**Bankfield Drive, Holmbridge
Proposed Internal Site Layout and Off-Site Works
Response Report to Road Safety Audit Stage 1**

November 2023 (Revision 3)

Report title	Bankfield Drive, Holmbridge Response Report to Road Safety Audit Stage 1 – Rev 3
Date	22 nd November 2023
Document reference and revision	Response Report to Road Safety Audit Stage 1- Rev 3
Prepared by	Optima Highways and Transportation Ltd
On behalf of	Kirklees Council

ROAD SAFETY AUDIT

AMEND GIVEWAY ROAD MARKINGS ON DOBB TOP ROAD TO ENCOURAGE BANKFIELD DRIVE DRIVERS TO PULL UP CLOSER TO CENTRE LINE AND COMPACT THE JUNCTION

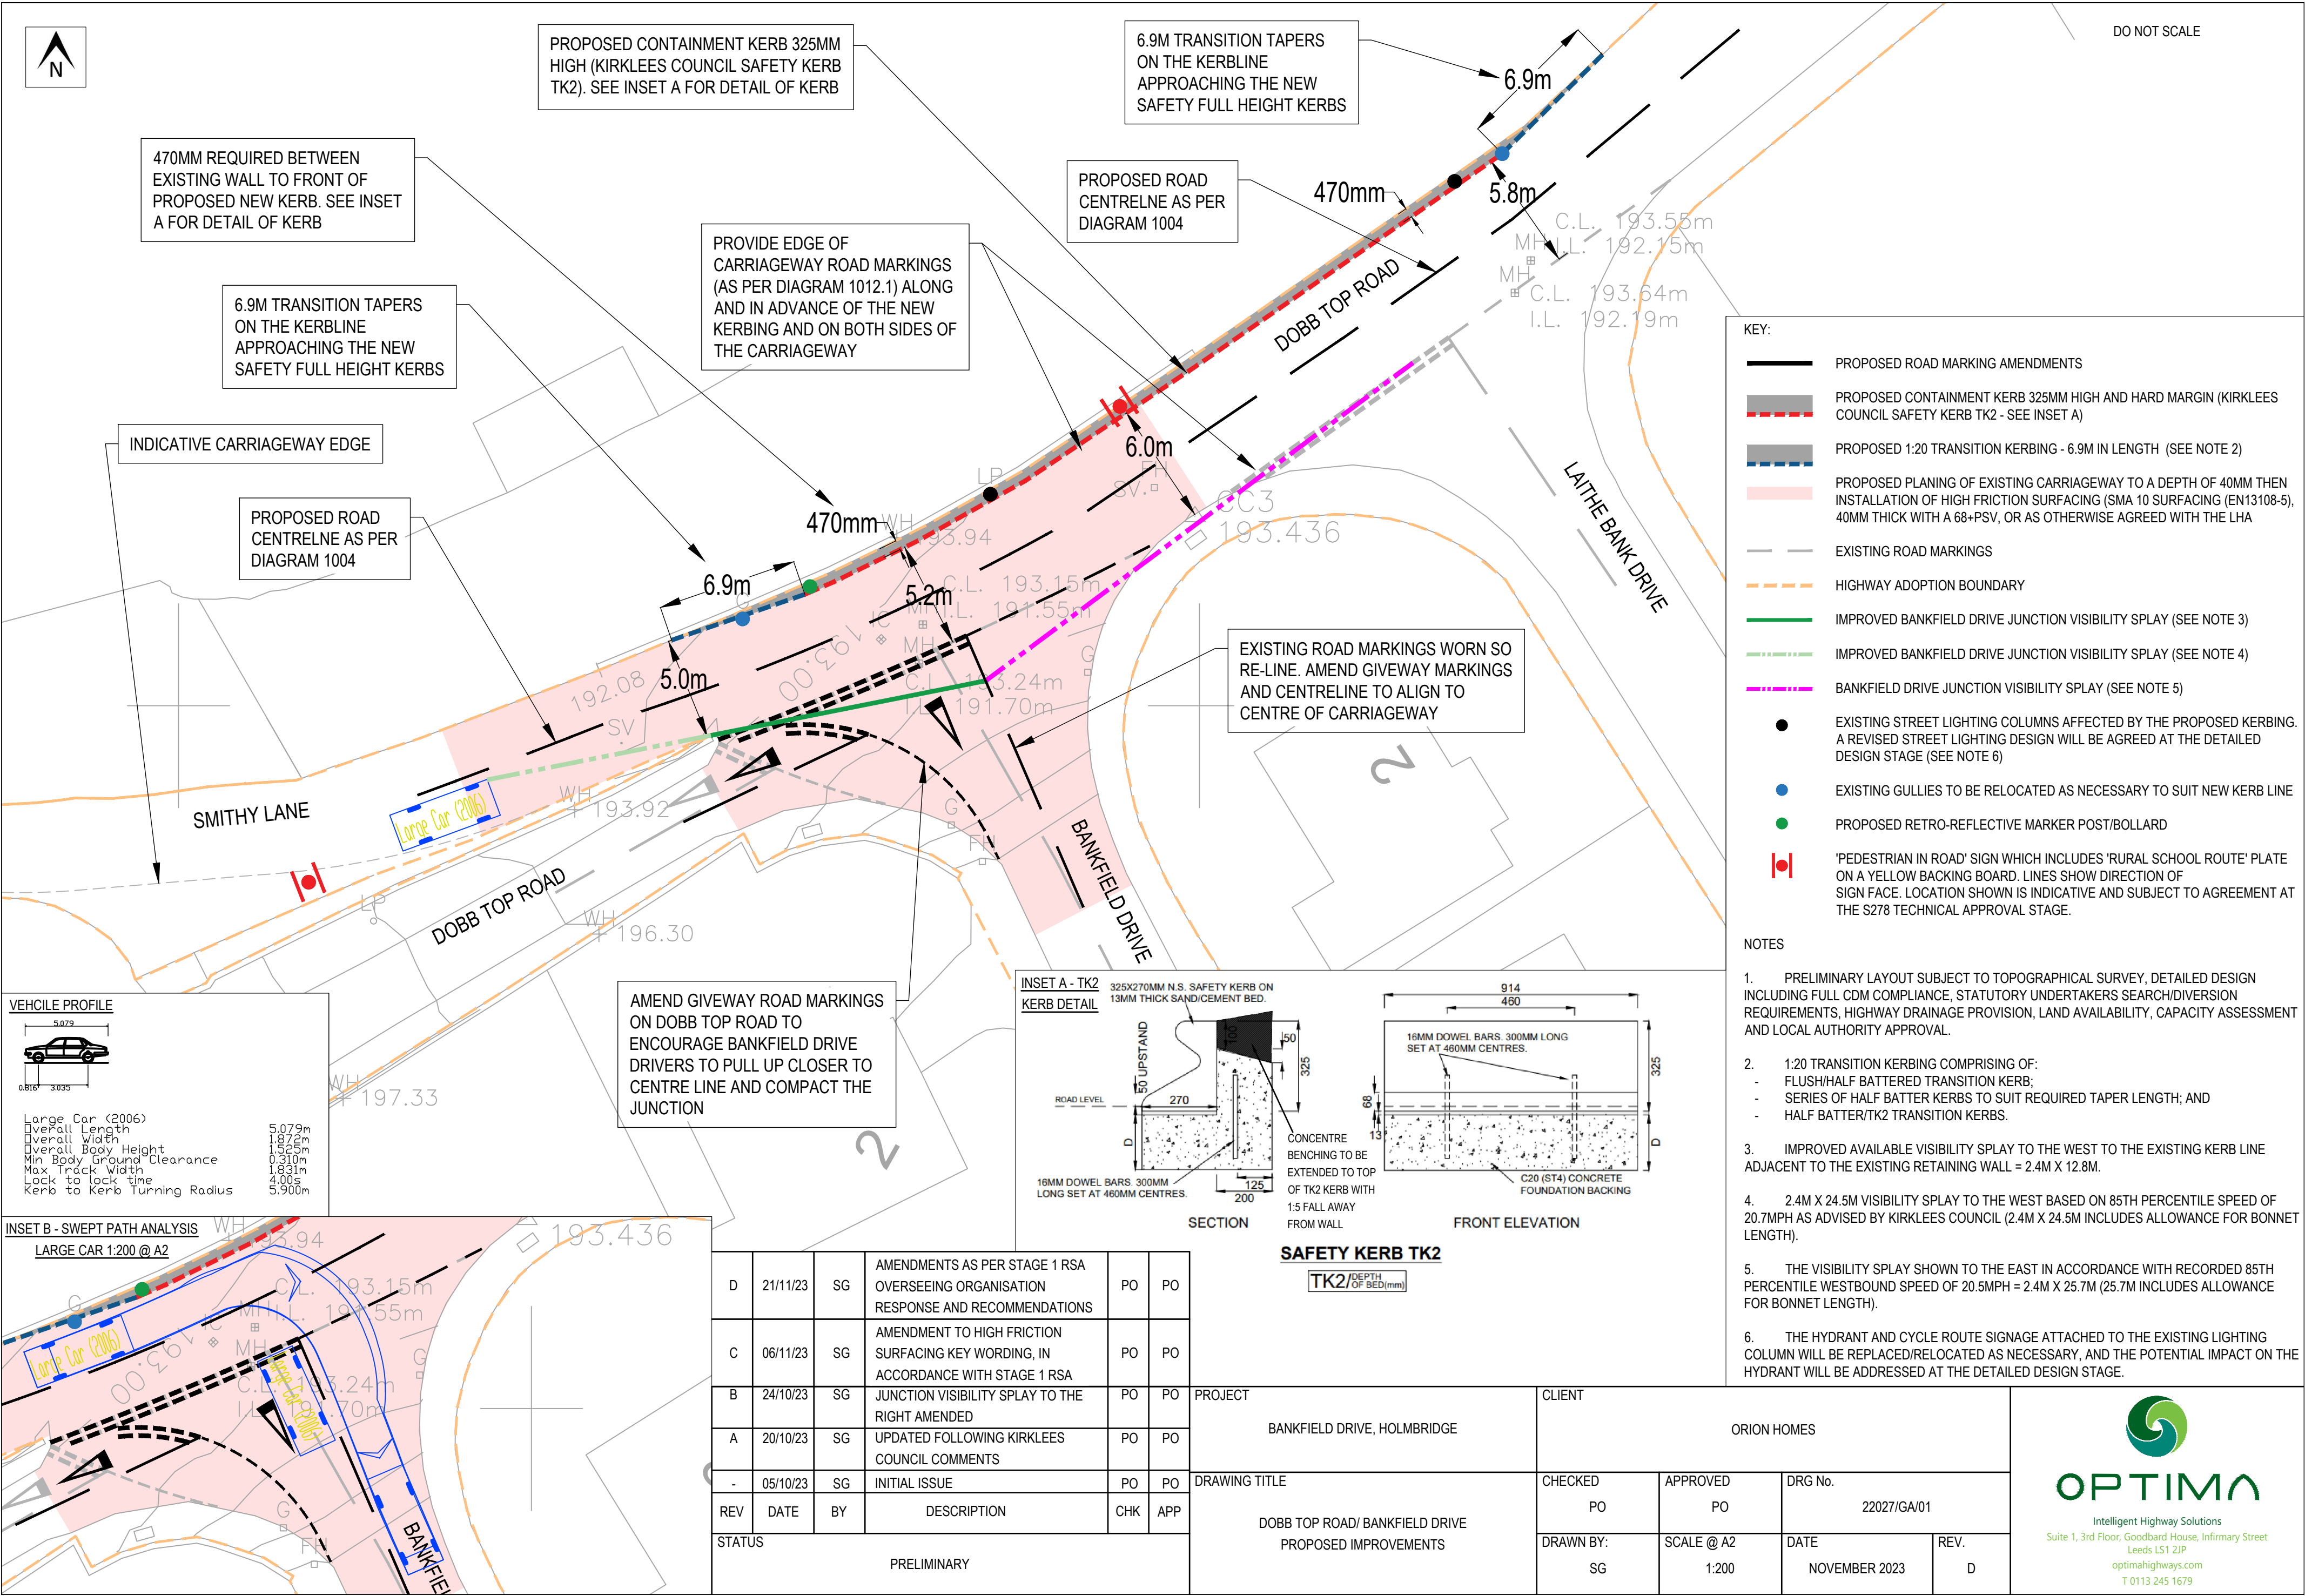
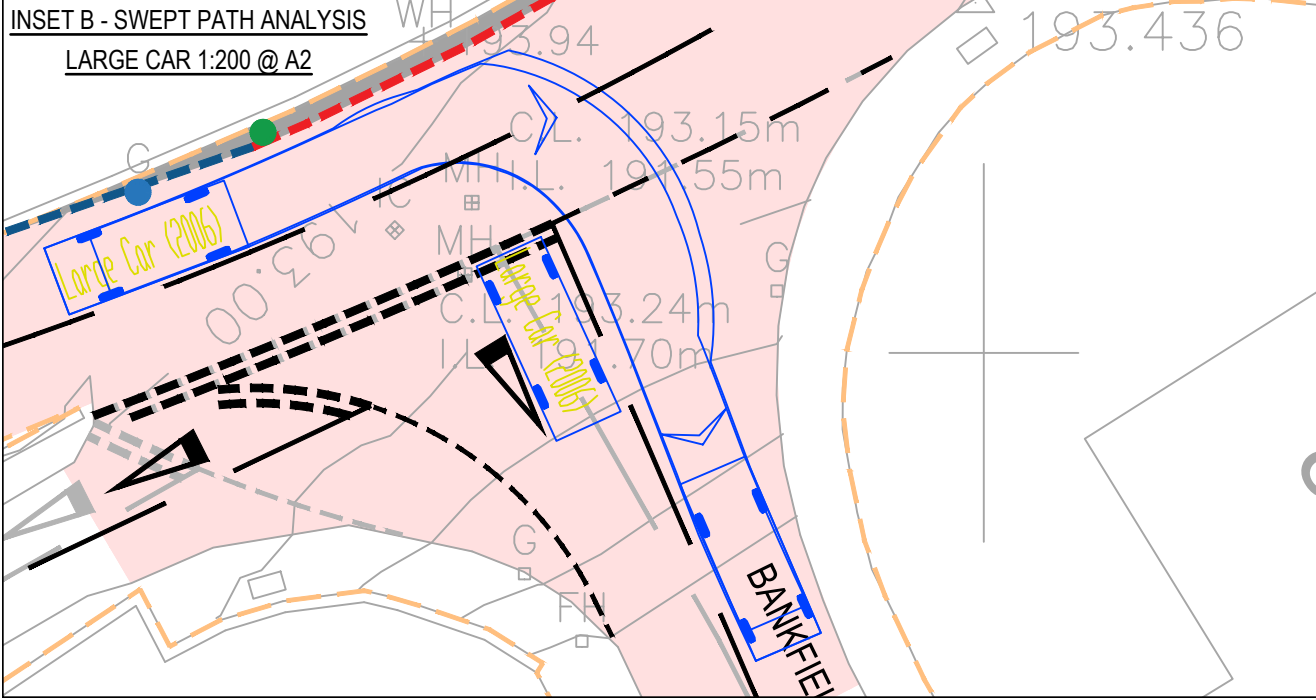
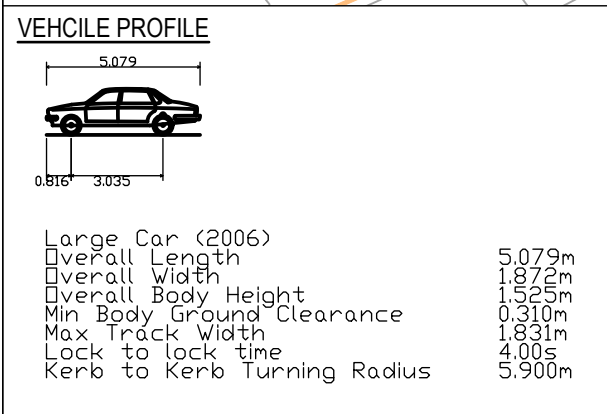
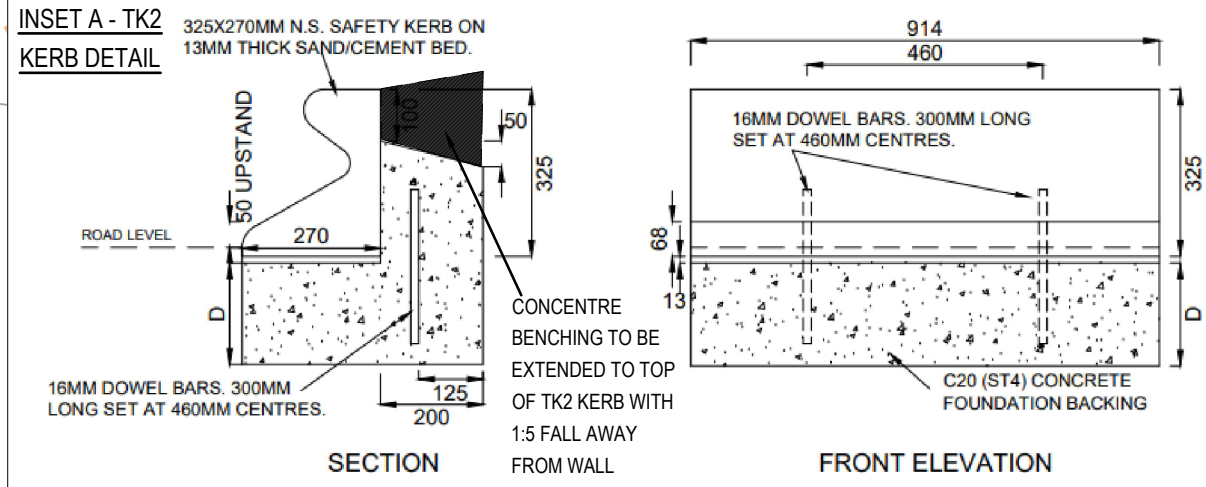
3.3 Problem: Inadequate taper lengths to buildout.

Summary: *The proposed tapers lengths are considered inadequate and could lead to collisions with the containment kerbing / sharp weaving movements.*

The drawings show the proposed taper lengths to the build out to be 6.9m based on 1 in 20 tapers. Given the construction of the containment kerbing with concrete backing is shown to be 470mm, a 1 in 20 taper would need to be a minimum of 9.4m.

In addition, the drawings give the impression that the entire taper might be constructed using containment kerbing which clearly cannot be the case.

Failure to provide an adequate taper length could lead to collisions with the proposed build out containment kerbing and potential loss of control type incidents.

5.1 Problem: Proposed warning signs obscured by vegetation / overhang highway

Summary: *The two pairs of pedestrians in road warning signs / rural school route signs would be obscured by vegetation and overhang into carriageway so might not be seen / hit by passing vehicles.*

5.3 Problem: Proposed lighting column locations impracticable.

Summary: *The two lighting columns affected by the kerb buildout will not be maintainable as is and if replaced in same location have reduced are affected by tree canopy reducing conspicuity of the junction works in hours of darkness.*

The drawings provided indicate that two lighting columns “existing lighting columns to be either relocated out of the carriageway; or to remain in situ behind the” vehicle containment kerbs.

The Audit team is of the opinion that it is not possible to retain these columns in situ as the height of the containment kerbing will then not allow access to the maintenance panel on each column. On site observations show that the existing location of each of these columns means that the lanterns are within the adjacent tree canopies and so their illumination of the carriageway is reduced.

5.5 Problem: Lack of hazard road markings through junction.

Summary: *The drawings do not show the hazard markings continuing through the junction leading to confusing messages being given to drivers and potential head on collisions.*

The drawings provided to the Audit team do not indicate the continuation of the central hazard warning lines to Diag 1004 through the junction – indeed they stop short of the junction on each approach.

RSA Problem	RSA Recommendation	Design Organisation Response	Overseeing Organisation Response	Agreed RSA Action
			Section 59 of the Highways Act 1980.	
3.3 Problem: Inadequate taper lengths to buildout Location – Smithy Lane / Dobb Top Road. Summary – The proposed tapers lengths are considered inadequate and could lead to collisions with the containment kerbing / sharp weaving movements. Detail – The drawings show the proposed taper lengths to the build out to be 6.9m based on 1 in 20 tapers. Given the construction of the containment kerbing with concrete backing is shown to be 470mm, a 1 in 20 taper would need to be a minimum of 9.4m. In addition, the drawings give the impression that the entire taper might be constructed using containment kerbing which clearly cannot be the case. Failure to provide an adequate taper length could lead to collisions with the proposed build out containment kerbing and potential loss of control type incidents.	It is recommended that a 1 in 20 taper be provided on the approach to and exit from the build out using a mixture of containment kerbing, transition kerbing to normal kerbs and normal kerbing.	The drawing clearly shows which length is transition kerbs (dashed blue line) and which lengths are full height kerbs (dashed red line). Details of the transition kerb types is also given in Note 2 on the drawing and is as follows: Flush/half-battered transition kerb (with back of flush section abutting wall) - Half batter kerbs to suit required taper length - 2 No. half batter/TK2 Transition kerbs. The proposed 6.9m long transition taper shown on the drawing is correct and is calculated as follows:	The RSA recommendation is partially accepted, as a 1:20 taper is required. However, the Design Organisation Response is accepted, as the design appears to provide the necessary 1:20 tapers. That said, the final kerbing details will need to be agreed at the S278 Technical Approval stage, and must ensure that 1:20 tapers are achieved. To highlight the presence of the new kerbing, it is also suggested that edge of carriageway markings are provided along, and in advance of, the new kerbing on both sides of the carriageway, as advised at Section 2.5 of TSM Ch 5 (also see Design	1:20 taper will be provided and the final kerbing details will be agreed at the S278 Technical Approval stage. Note added to Optima Drawing 22027/GA/01_REV D in relation to edge of carriageway markings to be provided along, and in advance of, the new kerbing on both sides of the carriageway, as advised (Diagram 1012.1).

RSA Problem	RSA Recommendation	Design Organisation Response	Overseeing Organisation Response	Agreed RSA Action
		270mm full width TK2 kerb + 200m benching = 470mm 125mm wide Flush/half-battered transition kerb Hence offset = 345mm (470mm – 125mm) Hence 6.9m taper length = 6.9m (20 x 0.345)	Organisation Response to Problem 5.5).

5.1 Problem: Proposed warning signs obscured by vegetation / overhang highway Location – Smithy Lane / Dobb Top Road Summary – The two pairs of pedestrians in road warning signs / rural school route signs would be obscured by vegetation and overhang into carriageway so might not be seen / hit by passing vehicles. Detail – There are two pairs of pedestrians in road / rural school route signs proposed. The pair on Smithy Lane appears to be a replacement for the ones that existed in 2015 as shown in the photograph below. It may be the above sign assembly has been removed following a collision with a passing vehicle as it is not there now. The proposed position for the new sign assembly on Smithy Lane would appear to be within the clump of	It is recommended that the proposed locations of the two pairs of signs be revised and placed away from vegetation that is likely to obscure it and the appropriate vehicle clearances be provided if possible.	The position of the pedestrians in road / rural school route signs have been carefully considered and discussed with Kirklees Council and are considered to be in the most appropriate locations bearing in mind the constraints along the road, particularly Smithy Lane. The vegetation maintenance point is a matter for Kirklees Council and is not a reason to invalidate the sign location.	The RSA Recommendation is partially accepted. However, the Design Organisation Response is not accepted. Whilst the indicative sign locations shown may be appropriate, the final location and sign details will need to be agreed at the S278 Technical Approval stage, ensuring there is adequate visibility and carriageway clearances. For the signs located next to the new kerbing, these would need to be installed on a cranked pole or offset bracket, to ensure there is adequate clearance from the carriageway.	Final sign locations and details to be agreed at the S278 Technical Approval stage. Optima Drawing 22027/GA/01_REV D key text amended to suit.

5.3 Problem: Proposed lighting column locations impracticable Location – Smithy Lane / Dobb Top Road Summary – The two lighting columns affected by the kerb buildout will not be maintainable as is and if replaced in same location have reduced are affected by tree canopy reducing conspicuity of the junction works in hours of darkness. Detail – The drawings provided indicate that two lighting columns “existing lighting columns to be either relocated out of the carriageway; or to remain in situ behind the vehicle containment kerbs. The Audit team is of the opinion that it is not possible to retain these columns in situ as the height of the containment kerbing will then not allow access to the maintenance panel on each column. On site observations show that the existing location of each of	It is recommended that a street lighting scheme be designed to ensure that the improved junction is illuminated in accordance with current guidance taking account of ongoing maintenance needs.	If the existing lighting columns are to remain in their current location following the installation of the safety kerb, the lighting columns could be raised slightly to a suitable height so that the maintenance panel can be accessed. Notwithstanding this Note 6 on Drawing 22027_GA01_REV C mentions the possible relocation of the existing lighting columns and this decision will be undertaken at the detailed design stage.	The RSA Recommendation is accepted, and the columns will need to be relocated/replaced. Therefore, the Design Organisation Response is not accepted, as it is clear the existing columns cannot remain in situ or be raised. As such, the key on the drawing should be amended to state: <i>‘Existing street lighting columns affected by the proposed kerbing. A revised street lighting design will be agreed at the detailed design stage (Also see note 6).’</i> Note 6 should also be clarified to confirm that:	Existing affected lighting columns will be relocated / replaced at the detailed design stage. Optima Drawing 22027/GA/01_REV D has been revised to amend key wording and note 6 following Overseeing Organisation Response comments.

5.5 Problem: Lack of hazard road markings through junction Location – Smithy Lane / Dobb Top Road Summary – The drawings do not show the hazard markings continuing through the junction leading to confusing messages being given to drivers and potential head on collisions. Detail – The drawings provided to the Audit team do not indicate the continuation of the central hazard warning lines to Diagram 1004 through the junction – indeed they stop short of the junction on each approach. The lack of continuing guidance to drivers through a junction can lead to incorrect paths being taken leading to collisions between oncoming vehicles.	It is recommended that the hazard markings to Diagram 1004 be continued through the junction.	The provision of the proposed centreline markings (Diagram 1004) along Dobb Top Road/Smithy Lane has been considered and agreed with Kirklees Council. The reason for showing the break in the centreline markings at the Bankfield Drive junction is that this section of carriageway is less than 5.5m wide. It is proposed to retain the current design.	The RSA Recommendation is accepted. Whilst the Design Organisation Response confirms why the centreline marking was omitted (as recommended in TSM Ch 5), the drawing was clearly dimensioned to show a 5.0m pinch-point in the carriageway, which the RSA Team will have observed. Therefore, there is no reason to ignore the RSA recommendation, which should be incorporated on the preliminary design plan. It is also suggested that edge of carriageway markings are provided along, and in advance of, the full length of new kerbing on both sides of the carriageway,	Optima Drawing 22027/GA/01_REV D has been revised to show a continuous carriageway centreline as recommended in the Overseeing Organisation Response comments.
